Subject: Warwick Nursery Barnham Road Eastergate Barnham PO203RT - BN/153/20/PL

Planning Application Reference: BN/153/20/PL

Proposal: 44 No. dwellings & associated infrastructure. This site falls within the BEW Strategic Site, CIL Zone 1 (Zero Rated).

Environmental Health has no objection in principle to this application, however the following matters must be considered:

Drawing Title
Housetype DDP

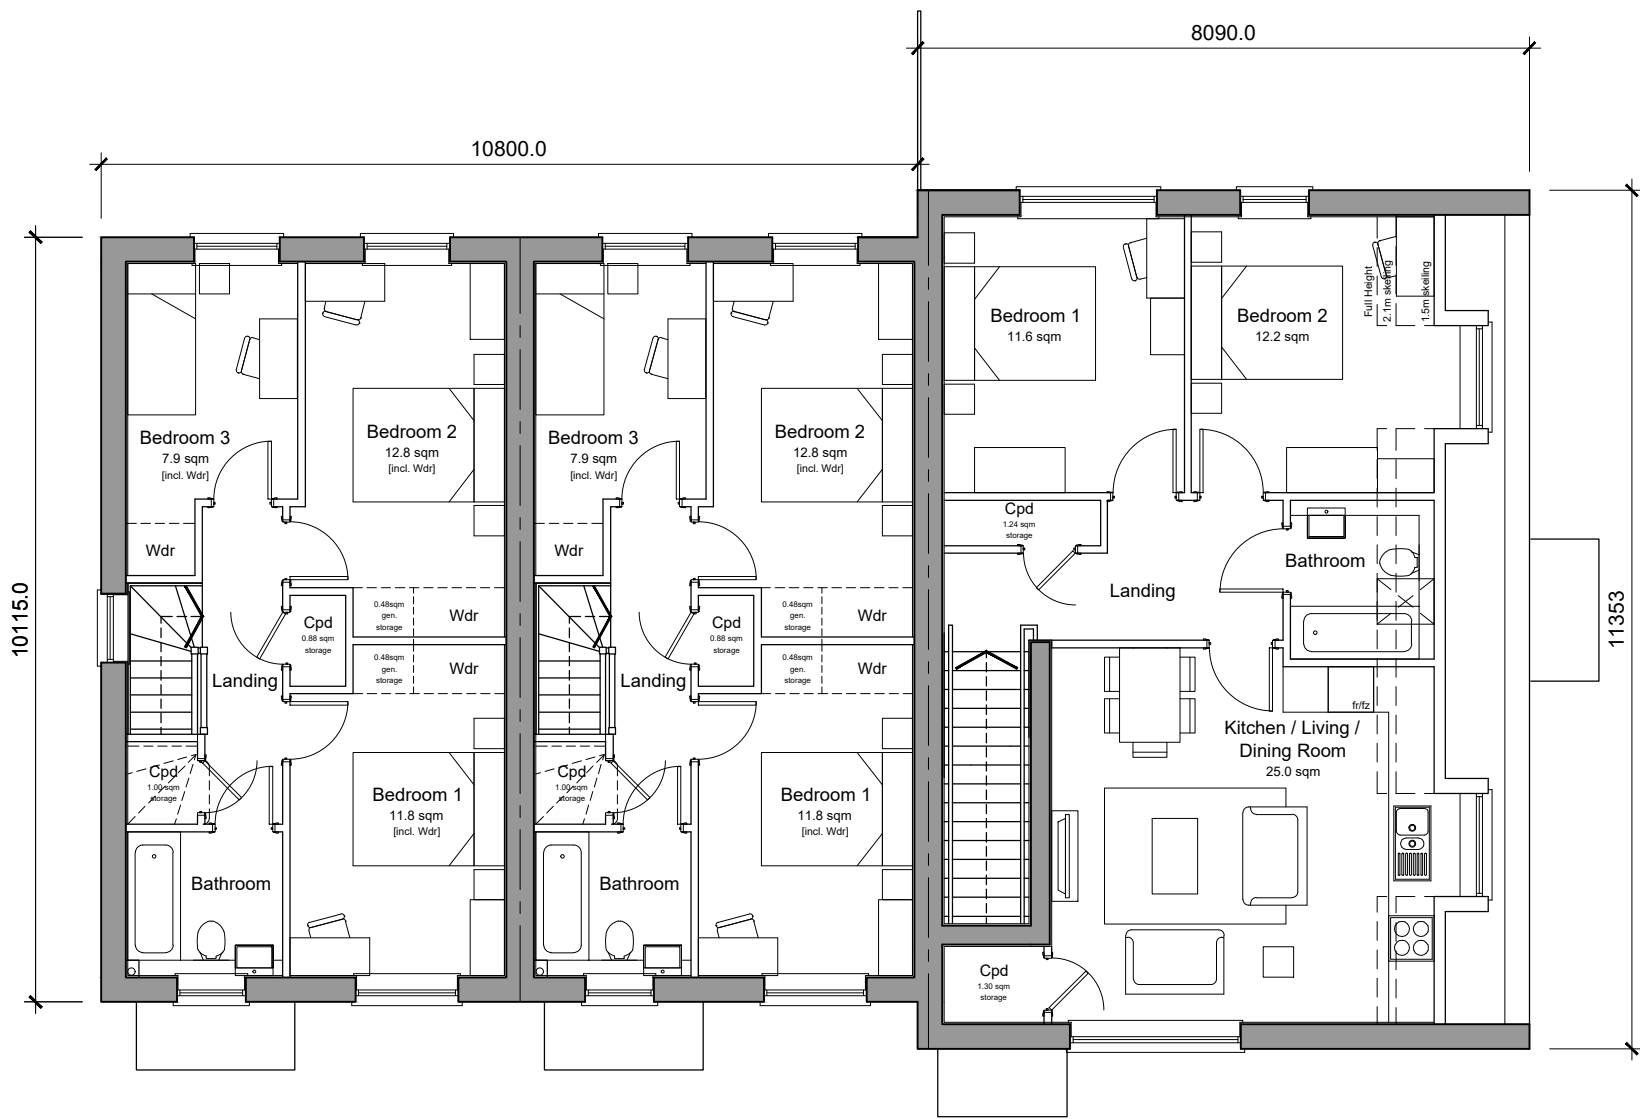
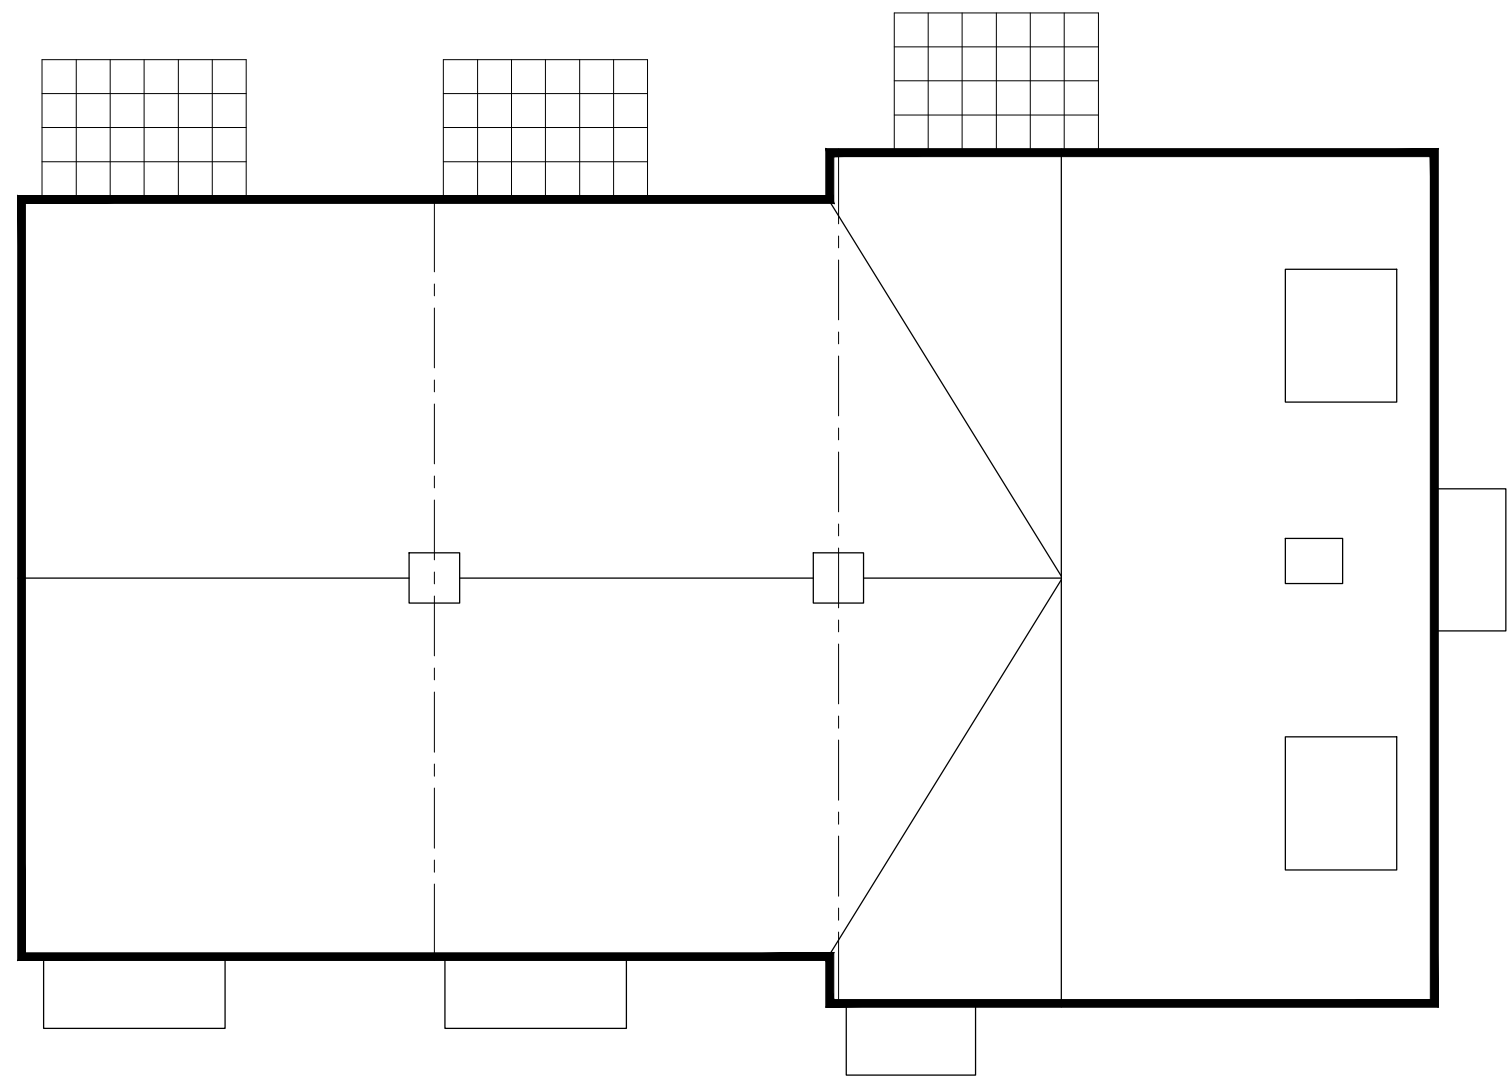
Proposed House type DDP includes a design and layout which is not ideal as the ground floor bedroom in house type P is adjacent to the living/dining room on the ground floor of house type D. Acoustically, this is not an ideal arrangement and may introduce a potential noise nuisance. I therefore recommend the following condition is attached to any permission granted:

The sound insulation of the party walls between the ground floor bedroom in house type 'P' and the living/dining room of house type 'D' shall achieve a minimum airborne sound insulation value of 50 dB ($D_{nT,w} + C_{tr}$). Before the residential unit is occupied, a test shall be undertaken by a competent acoustician and submitted to the Local Planning Authority to demonstrate compliance with this level.
